RE: Australian Turf Club SSD 5002-11 Application for Hotel

The Heritage Branch provides the following comments on behalf of the NSW Heritage Council.

NORTH ELEVATION

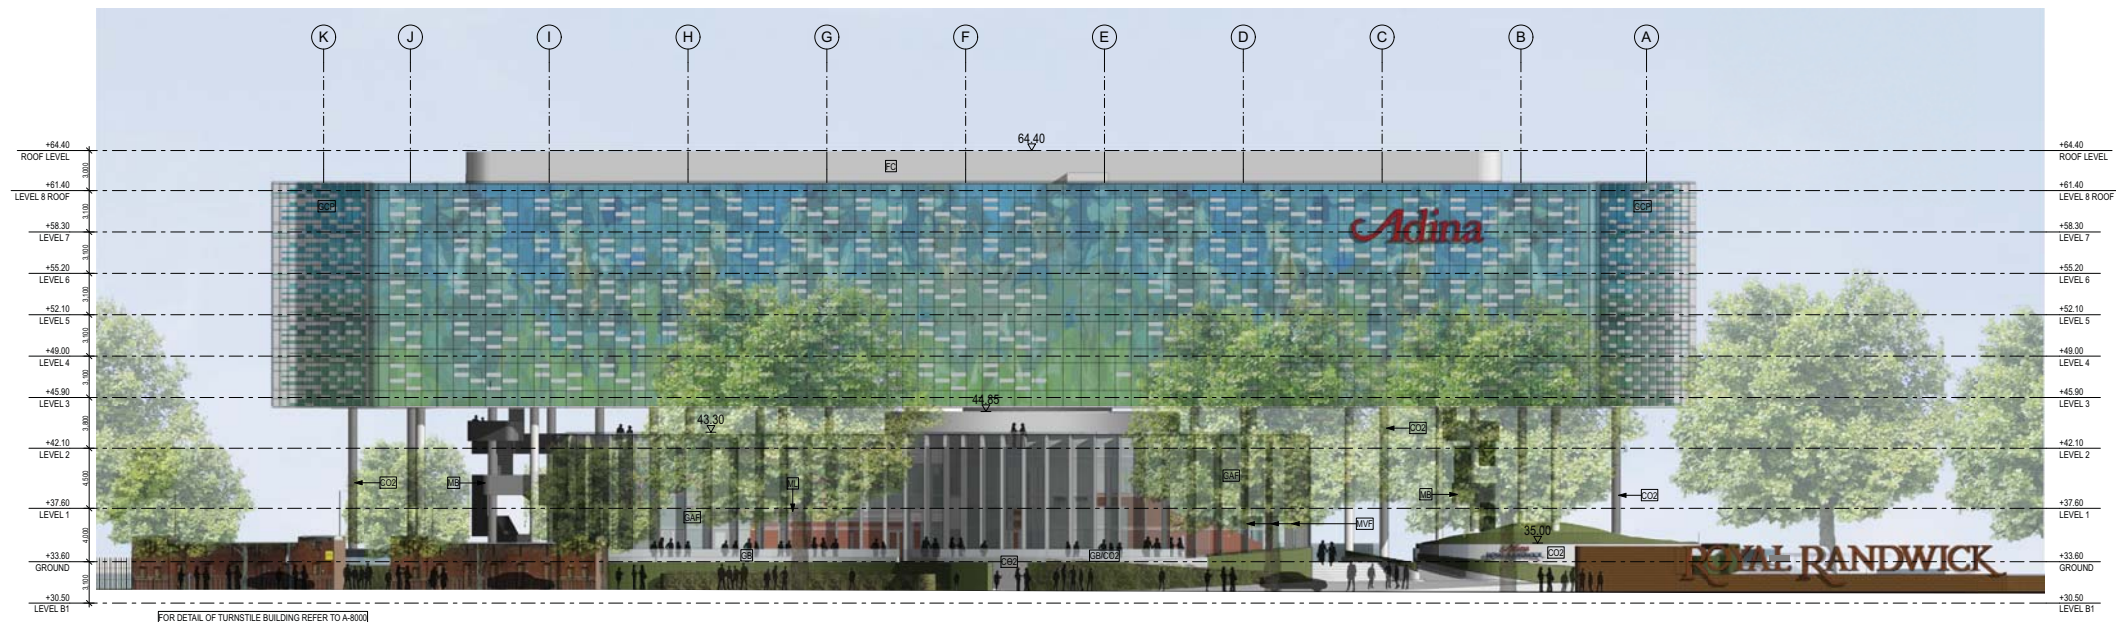
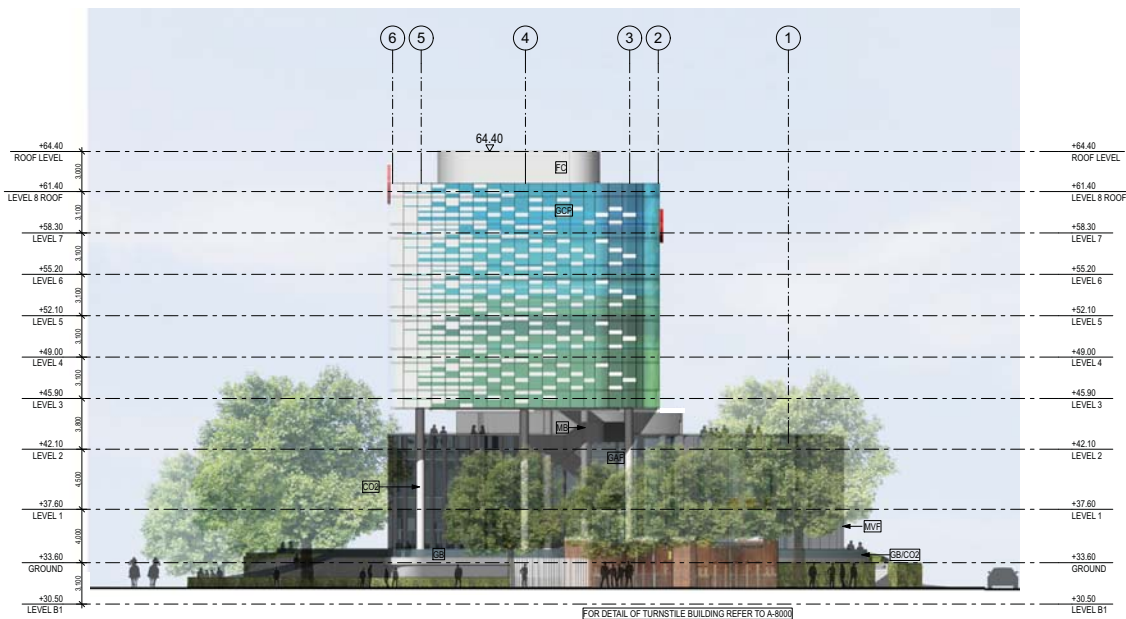
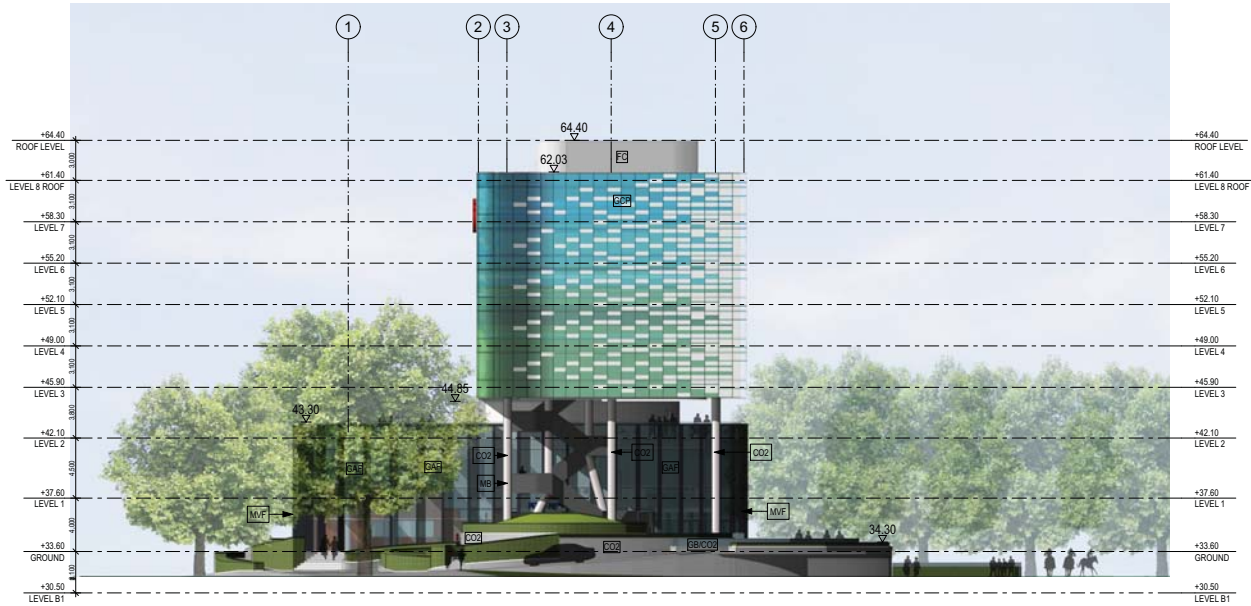
The Branch is of the opinion that the proposed hotel development is likely to dominate the adjacent Officials Stand. It is noted that none of the photomontages or architectural drawings included in the urban design document, prepared by Tonkin Zulaikha Greer, include photomontages showing the view of the Officials Stand, modern grand stands, the proposed hotel, outdoor bar and associated landscaping, from trackside. To assist in the assessment of the potential impacts of the proposed design scheme on the setting of Officials Stand, it is recommended that the Department request the applicant provide views (photomontages or fully articulated colour drawings) of the how the development would appear to spectators from trackside.

- The Heritage Branch supports in principle the design concept whereby the track facing elevation of the hotel (south facade) is designed to take on the guise of a grandstand, its terrace stepping down to the track. It is recommended that the Department seek further detail as to how this concept is to be expressed in the design of the hotel;
- The Branch notes that the impact of the proposed development on the setting of the former Turnstile Building is mitigated to some degree by the elevation of the eastern end of the proposed hotel two storeys above ground level;
- It is noted that the siting of the proposed hotel and the geometry of podium allows for the retention of views into the racecourse from Darley and Alison Roads.

TURNSTILE BUILDING GROUND PLAN

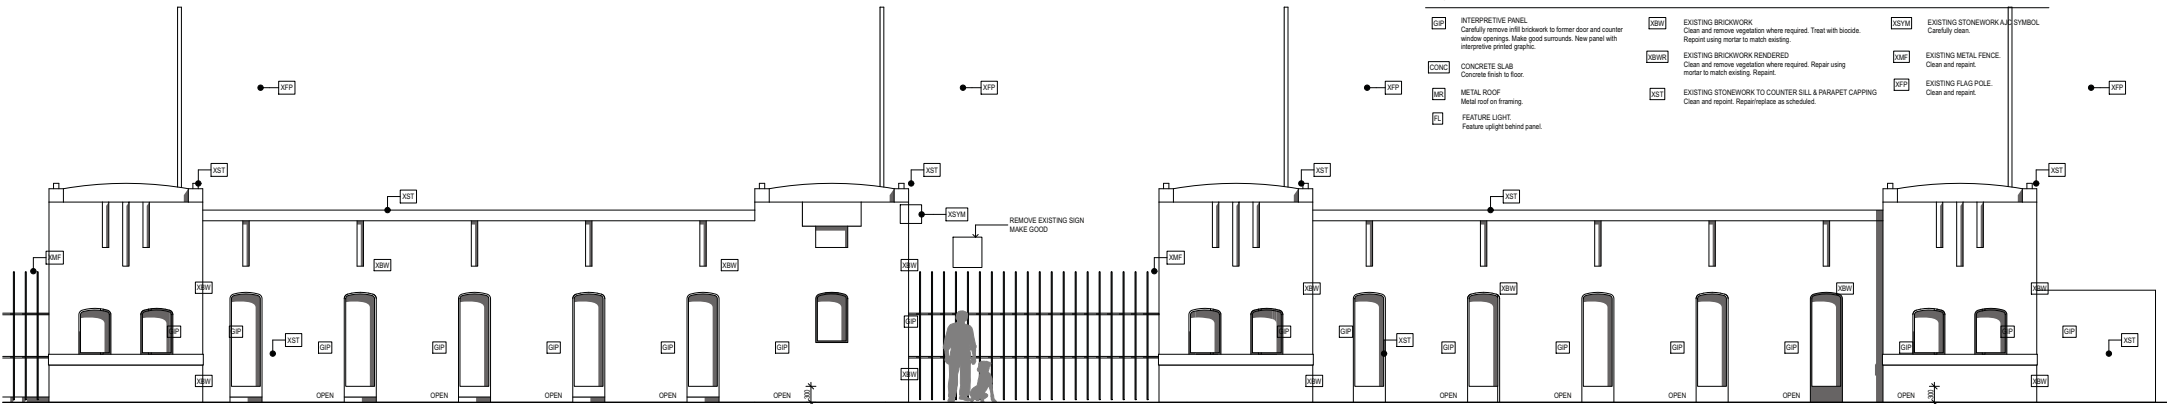
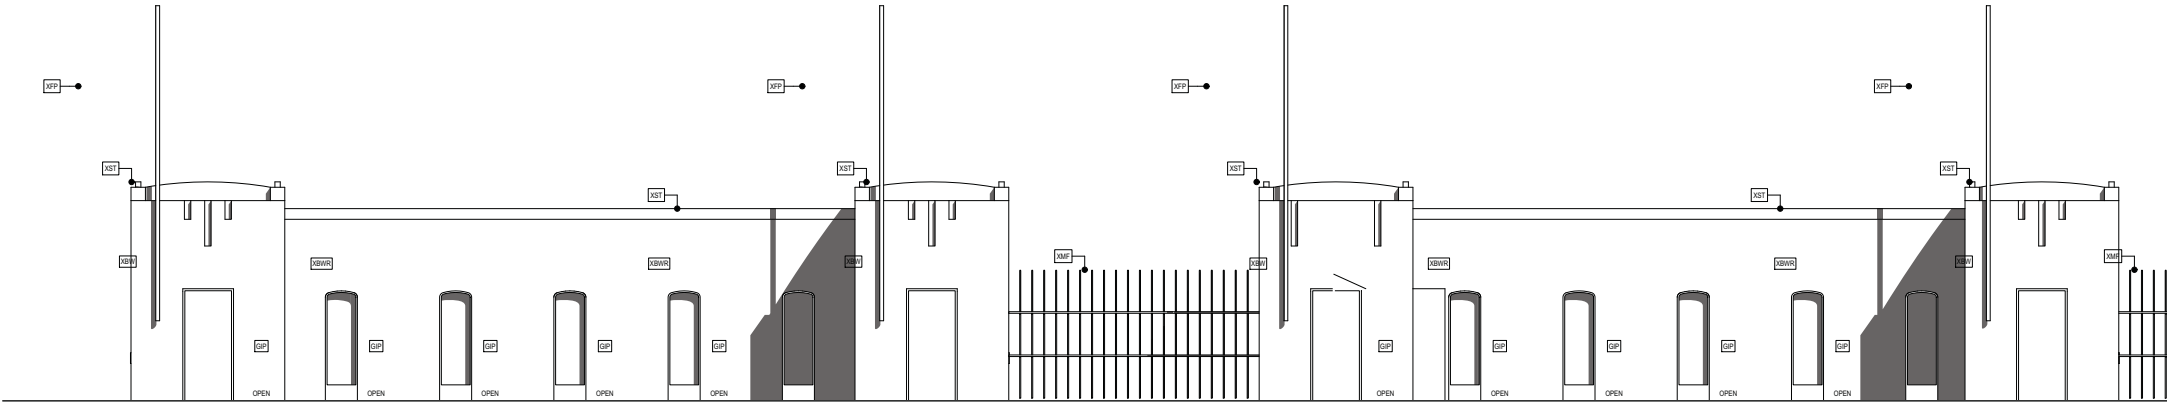
The former Entrance Turnstile (gates 6 & 7) is to undergo conservation works including replacement of missing doors to the former ticket booths. The openings of the pedestrian entry ways, which are currently bricked up, are to be partially reinstated to allow interpretation of their function. The Heritage Branch regards these works as a positive

In relation to the proposal that interpretative panels replace the brick infills to the pedestrian entry of the Turnstile, it is noted that there is an overview interpretation strategy for the site prepared by Godden Mackay Logan and revised by Graham Books and Associates. It is suggested that the Department seek clarification in regards to how the interpretation panels integrate into the overall interpretation strategy for the site. More detail should be sought as to what textual and visual content is to be included on the panels.

- A schedule of conservation works for the former Entrance Turnstile (gates 6 & 7) is to be prepared by a suitably qualified and experienced heritage practitioner. The schedule of conservation works is to be provided to the Heritage Council or its delegate for approval prior to the works commencing.
